CITY OF ALBUQUERQUE

September 20, 2013

Re: **Hampton Inn At The Sunport Grading and Drainage Plan**
Engineer's Stamp dated 9-05-13 (M15/D043)

ENGINEER'S SEAL  DAVID SOULE P.E. #14522	HAMPTON INN @ SUNPORT	DRAWN BY WCWJ
		DATE 7-27-13
	GRADING AND DRAINAGE PLAN	21226-LAYOUT-7-05-12
	 Rio Grande Engineering 1606 CENTRAL AVENUE SE SUITE 201 ALBUQUERQUE, NM 87106 (505) 872-0999	JOB # 21226

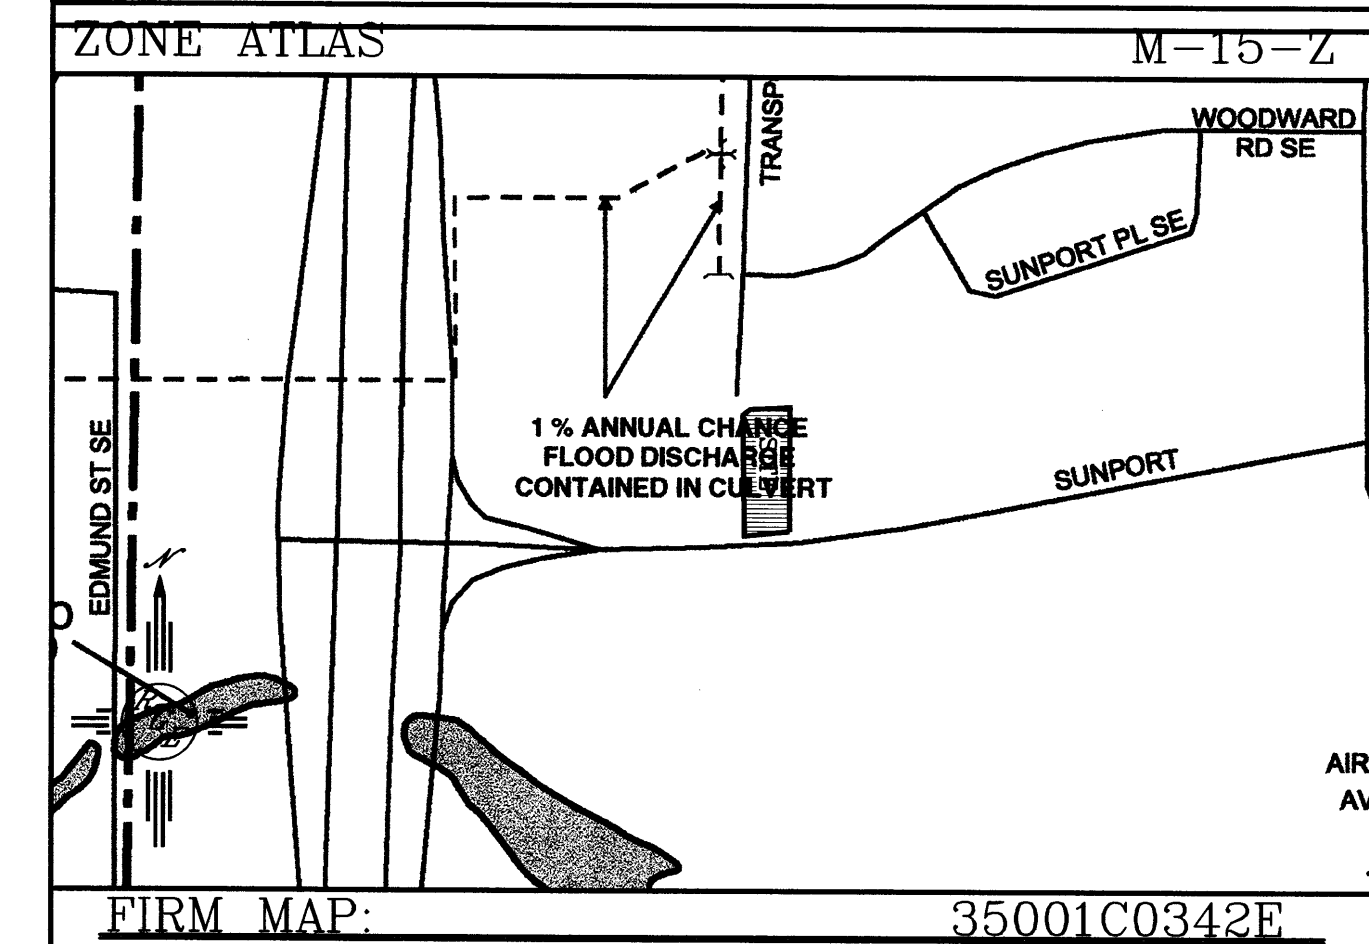
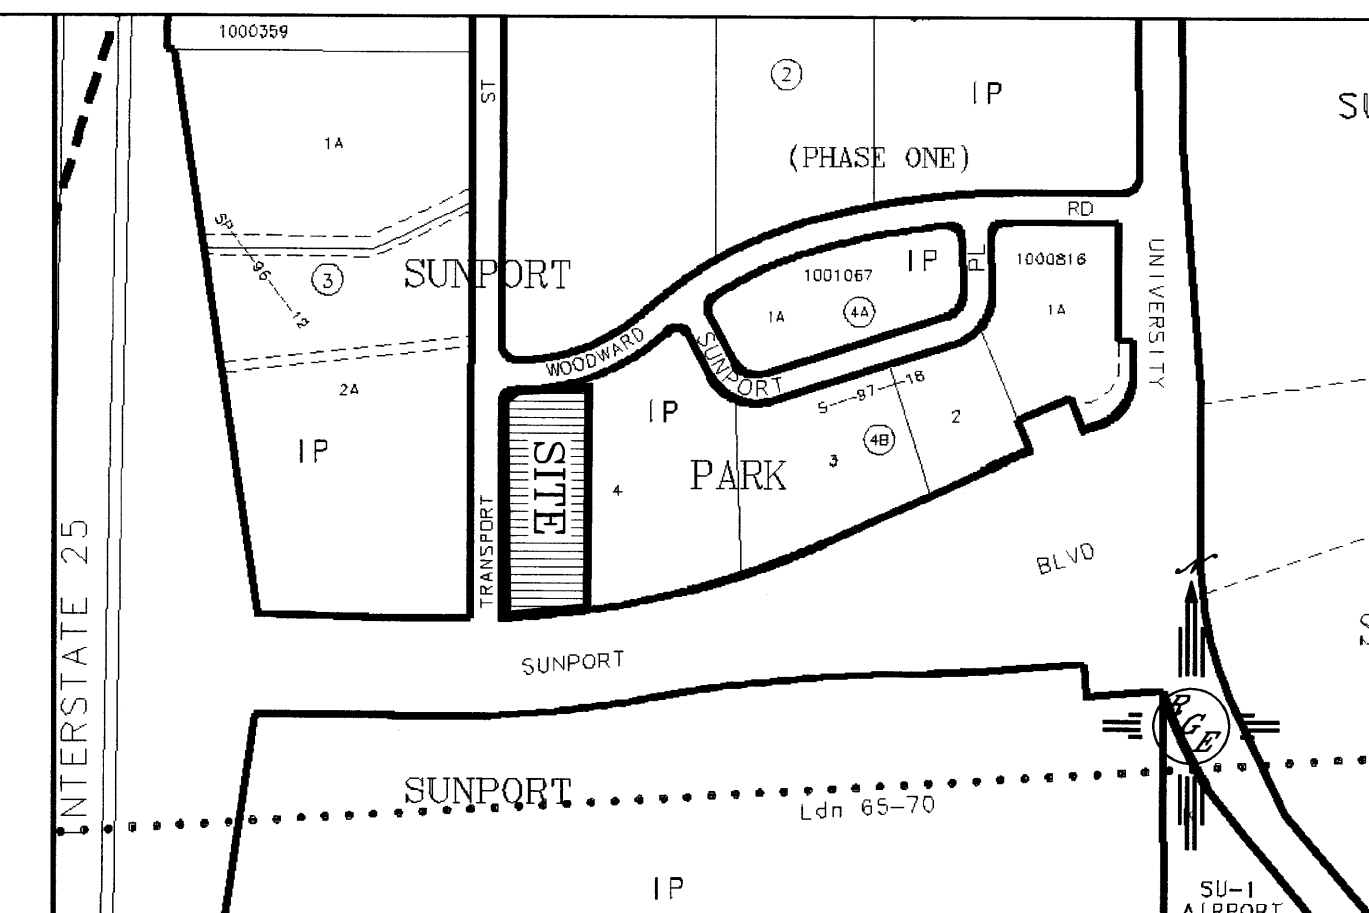
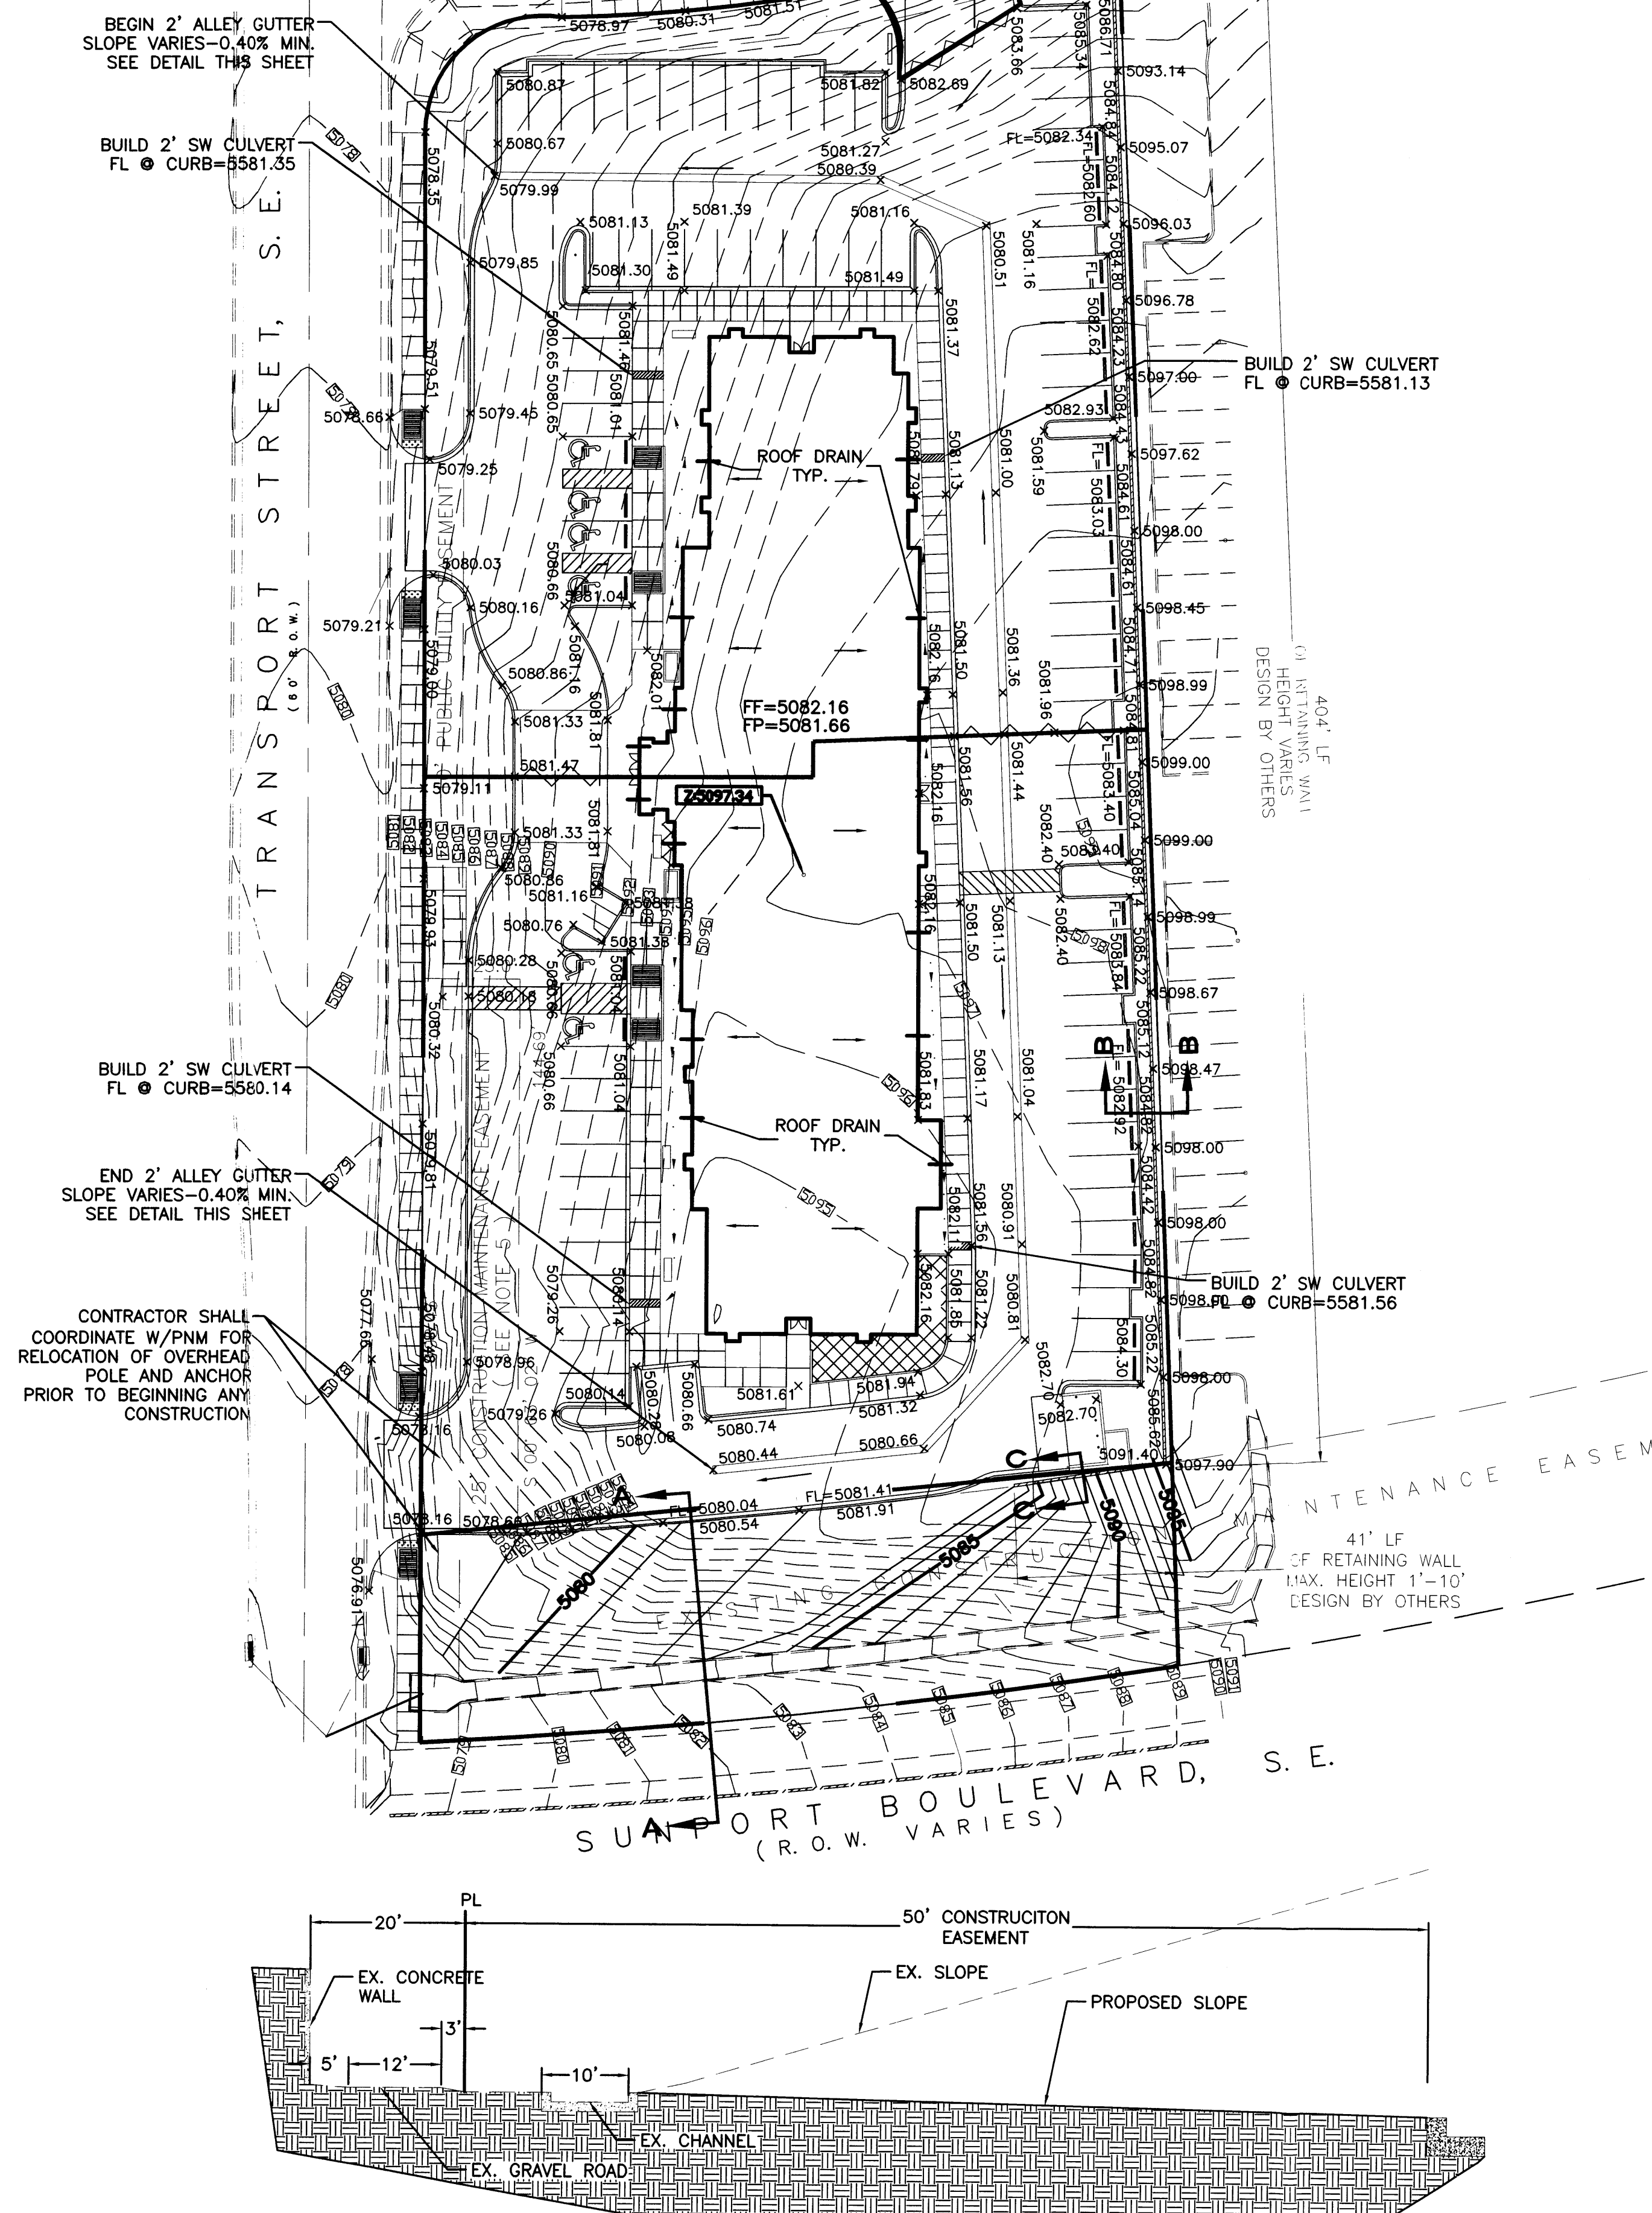
- Please make sure all the proposed spot elevations are legible.
- Easement is required from the property owner to the east for the placement of the retaining wall.
- As previously asked, please show the location of the cobble swale on the grading plan or remove the detail if a swale is not needed.
